10 June 2014

Attention: Director, Mining Projects

**Mannering Colliery – Section 75W Modification to MP06_0311 (MOD 2)
Chain Valley Colliery - Section 96 Modification to SSD-5465 (MOD 1)**

Client : EMGA
Job No/Name : MANNERING COLLIERY INTERSECTION Road Widths
Day/Date : Friday / 4th July 2014

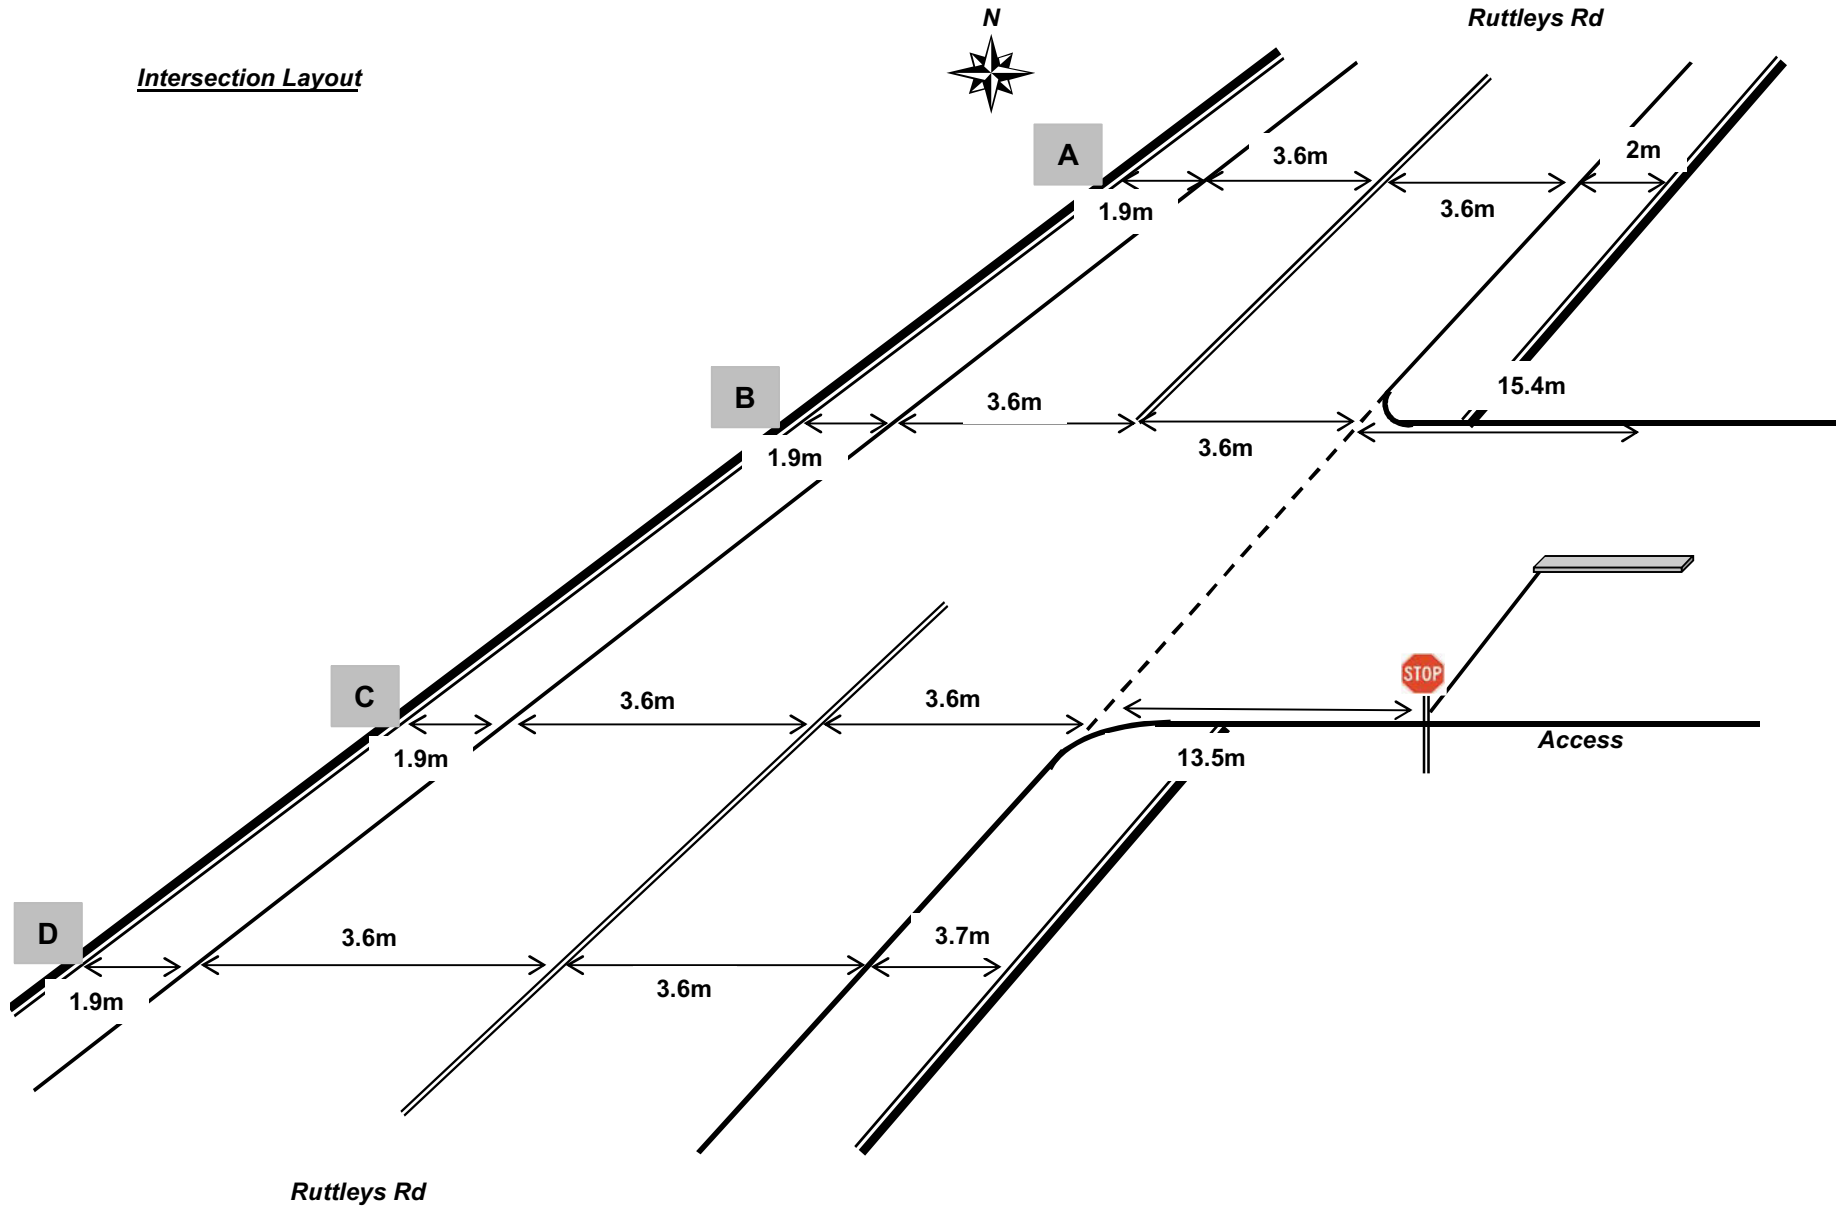
- It is noted that the 'Review of Ruttleys Road Intersection Upgrade Commitments' contained in Appendix D of the Environmental Assessment states that the recommendations of the road safety audit have been satisfactorily completed, although Council disagrees with this statement, particularly in relation to Item 7. Item 7 requires the reconstruction/repair of the shoulders on the approaches and departures to the intersection of Ruttleys Road/Access Road to allow vehicles to pass the intersection within the carriageway. The resurfacing that has occurred in this location comprises only a thin pavement for errant cars to regain control, not to pan right turning traffic. The existing pavement conditions do not provide diversion around right turning traffic and it this should be rectified prior to the recommencement of operations at Mannering Colliery.
